Application No: FG/155/25/PL

Site Address: Land between 11A The Grove and 30 Brook Lane Ferring BN12 5HZ

Description of works: Erection of 1 No 1-bedroom self build house with associated parking & private outdoor amenity space. This application is in CIL Zone 4 and is CIL Liable as a new dwelling.

Thank you for your internet representation made on 19th January 2026 which has been recorded as an objection with the comments as follows:

A :: Block Plan
01 scale: 1:200

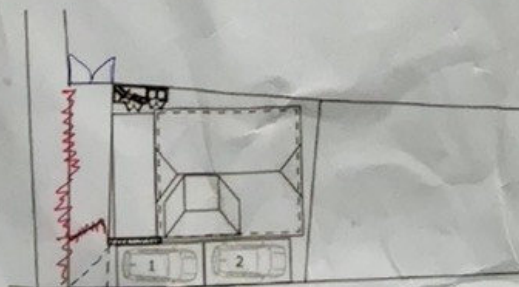
The site is insufficiently large to accommodate a dwelling and required amenity space without detriment to occupiers and neighbours alike.

Lowering the building 60cms below ground level will not change the fact that the site is much too small and this application, like its predecessors, remains an unduly cramped form of overdevelopment on a much too small site.

The proposed development has been moved even closer to the rear boundary of 28/30 Brook Lane than the previously rejected applications which were already deemed too close.

What are the drainage/flooding/subsidence implications for the proposed new dwelling as its ground floor will be below ground level and its garden space will be sunken? How will the stability of the right-of-way access across the north boundary (next to the sunken area) and the hard standing to the rear of 24's garden be kept structurally sound?
